**Application by Norfolk Boreas Limited for the Norfolk Boreas Offshore Windfarm.
The Examining Authority's written questions and requests for information (ExQ1)
Issued on 19 November 2019**

Please find attached answers to the highway elements of your request from Norfolk County Council (NCC) in its capacity as Local Highway Authority (LHA).

ExQ1: Tuesday 19 November 2019
Norfolk County Council Responses
Identification reference: 20022890

Bat Activity Survey locations  
(Map 1 of 16)

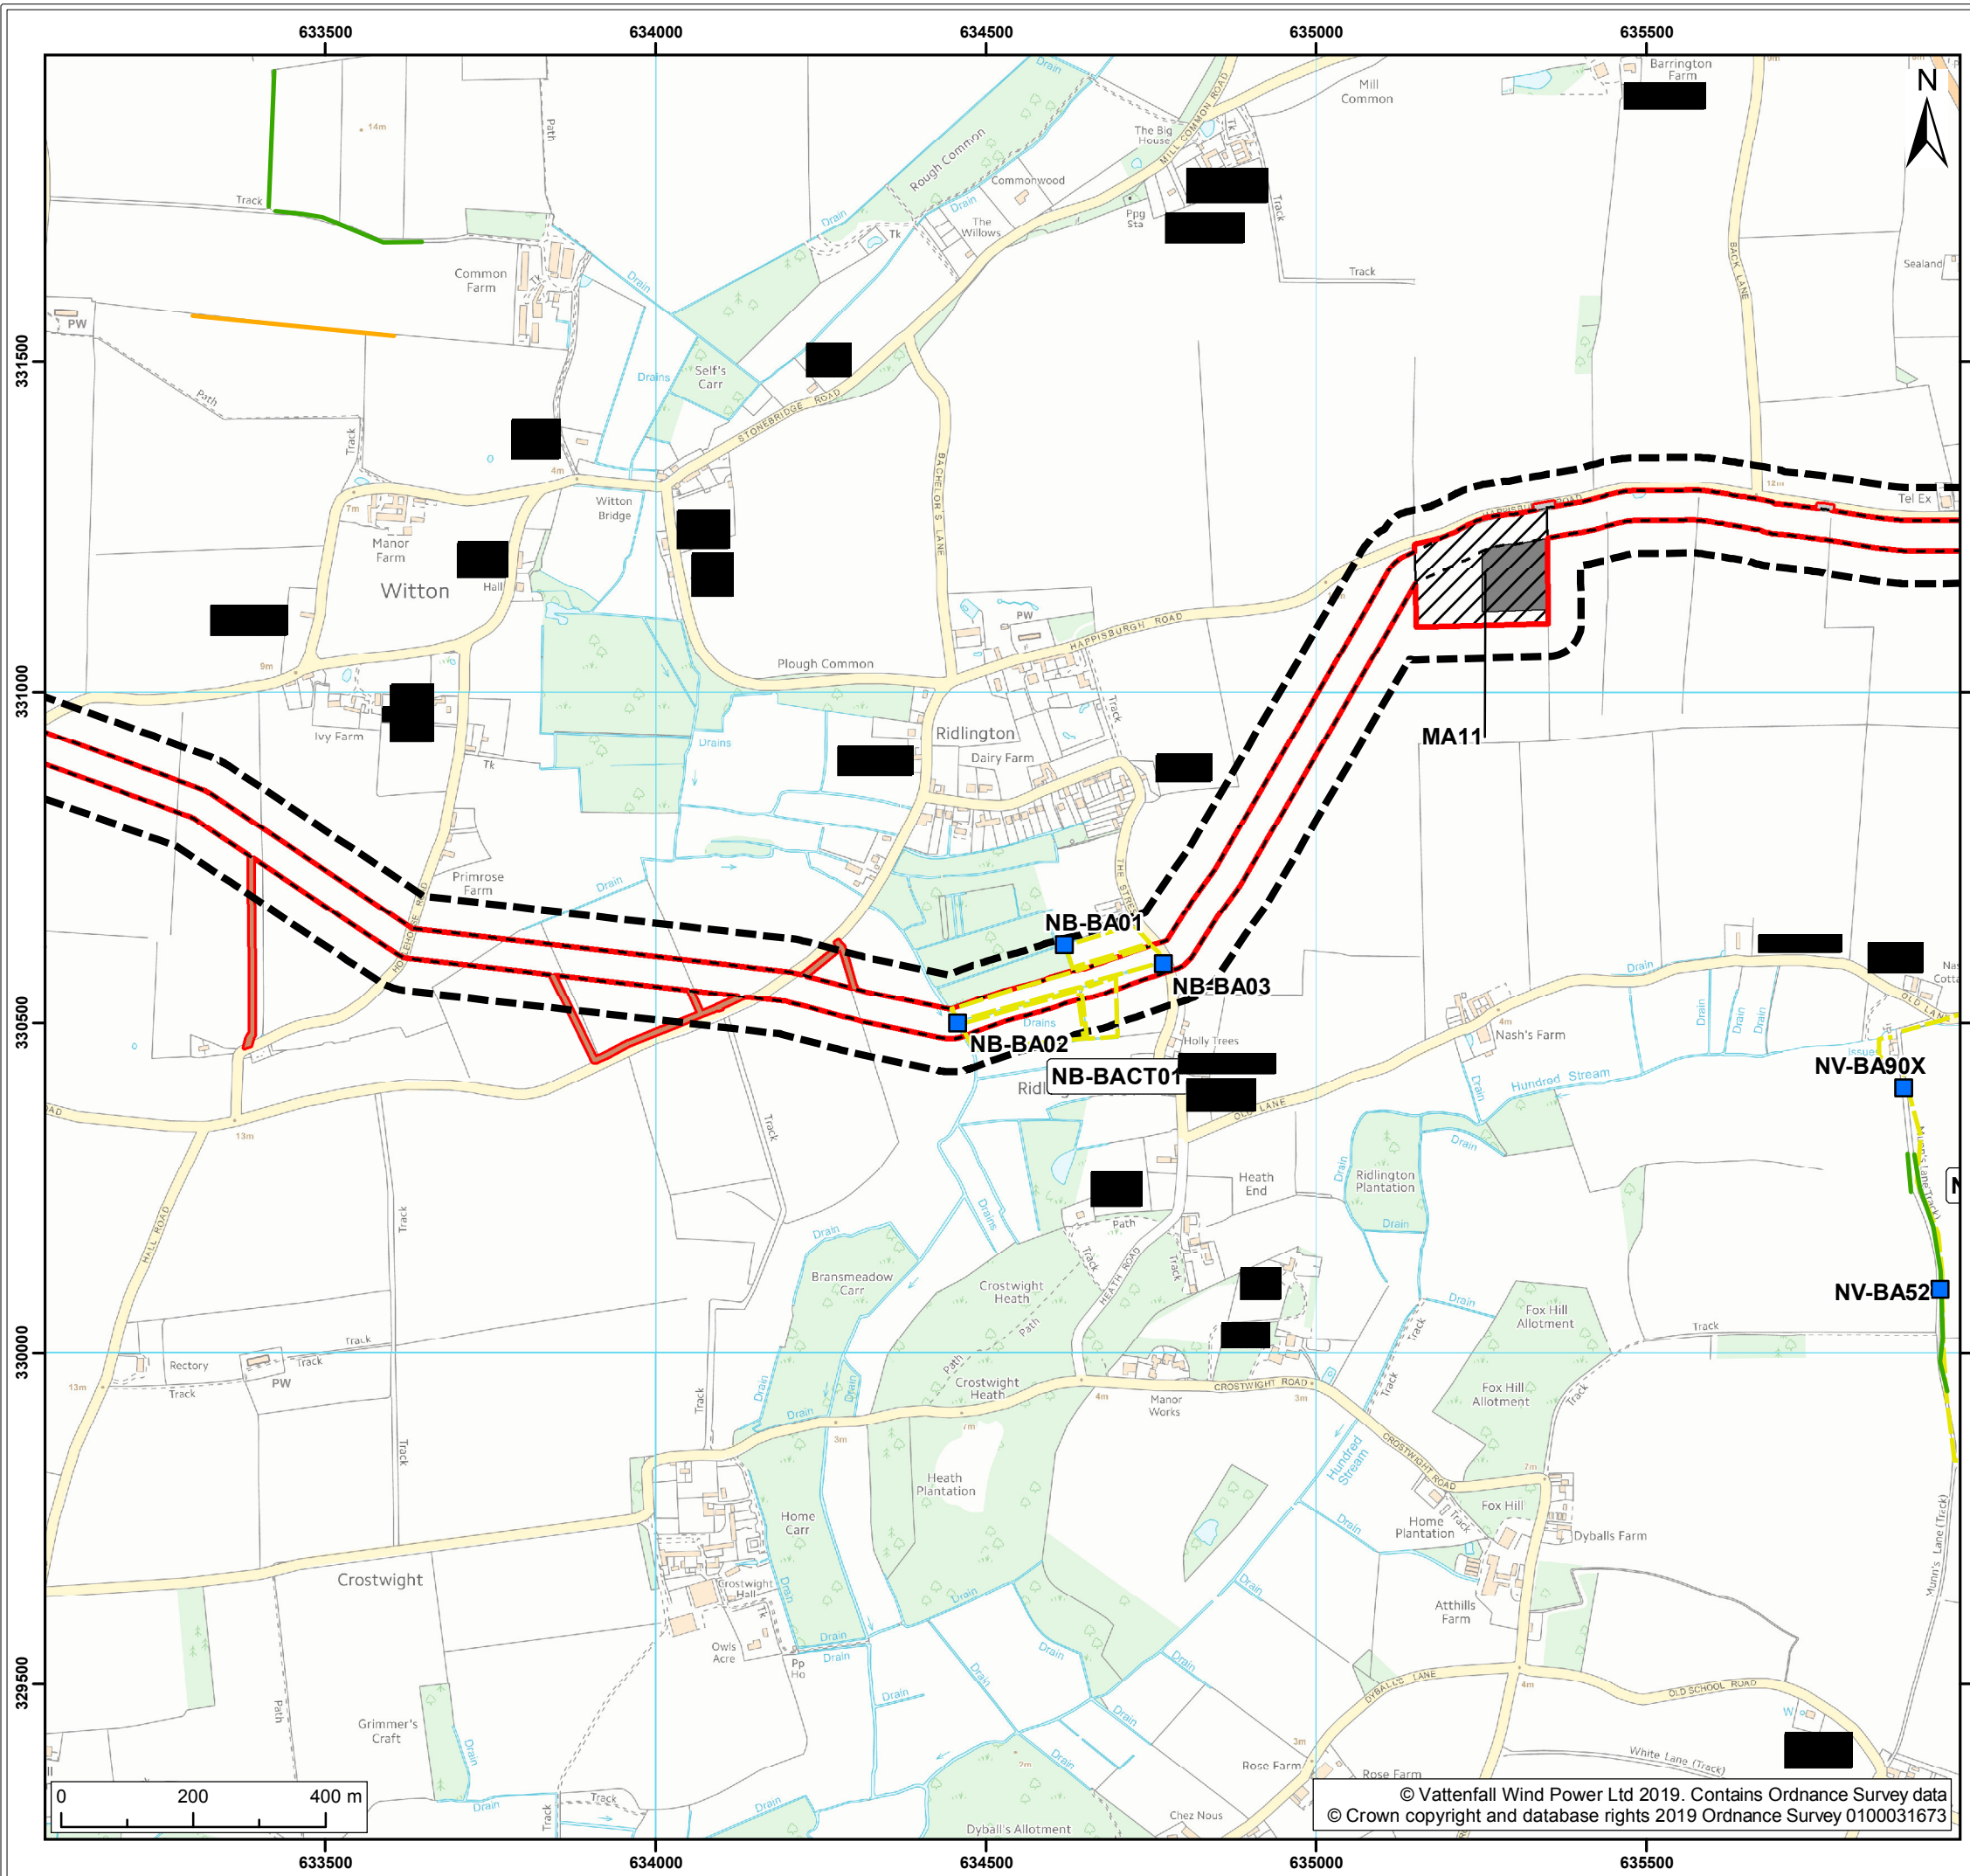
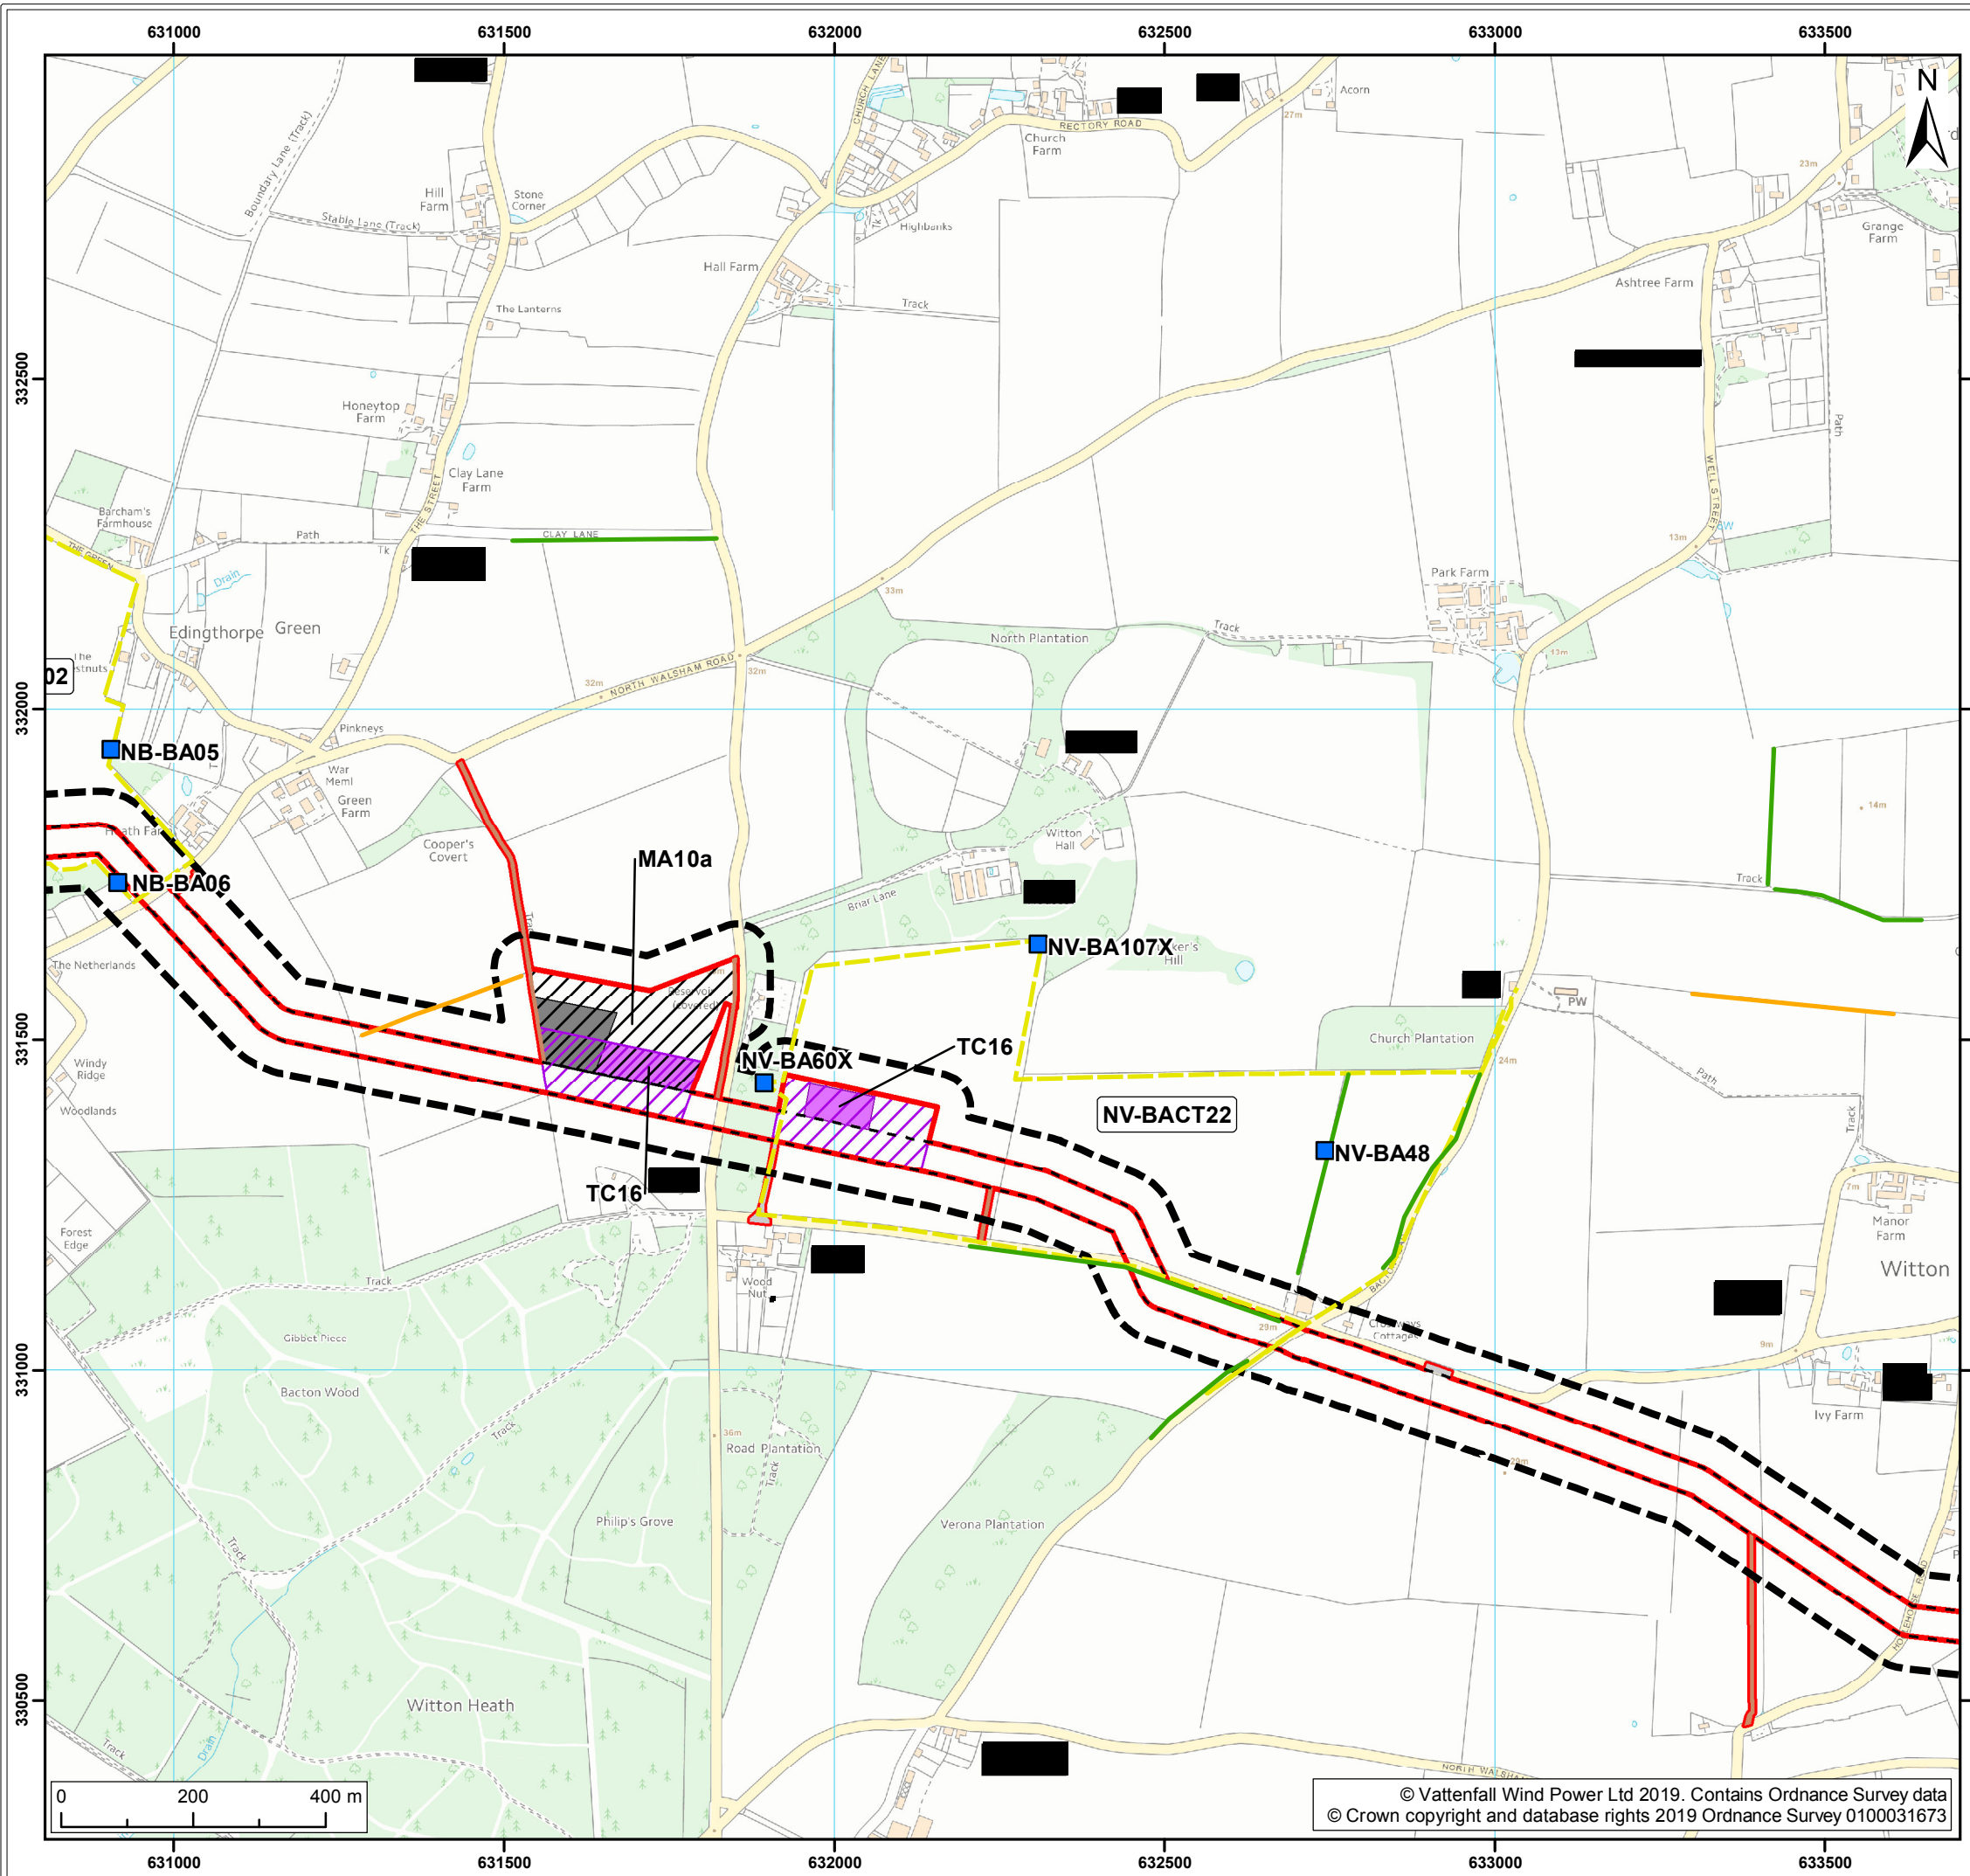
ExQ1	Question	Response
		<p>are? (Appendix 22.5² contains a report from November 2017; Appendix 22.04³ contains a report from February 2018 and Environmental Statement Figure 22.8 - Bat activity results⁴ contains maps from May 2018 showing bat activity survey locations, and Environmental Statement Figure 22.9 - Bat emergence results⁵ contains maps from dated April 2018).</p> <p>4. Table 22.9 (page 30) indicates that radiotracking data and other species roost data was obtained from Norfolk Barbastelle Study Group for the onshore project area and a 5km buffer. This is a misrepresentation as the data, notably radio tracking data, relates to Paston Barn SAC only rather than, as indicated, all barbastelle roosts within a 5km radius of buffer of the entire cable route.</p> <p>5. Table 22.21 (page 78) – hedgerow loss will be restricted to that required for access beyond the two-year duct installation phase, and will be no wider than 6 m. In Table 22.23 page 84 it says hedgerow gaps will be 13m long, possibly extending to 16.5 if crossed at an angle. Please can this be confirmed. (see Chapter 5 Project description – not reviewed at this stage).</p> <p>Comments on Assumptions</p> <p>1. Paragraph 83/84. Biological records data provided by NBIS includes records made almost exclusively by volunteers, the great majority of these data are collected by amateur experts in their field. All records provided by NBIS have a</p>
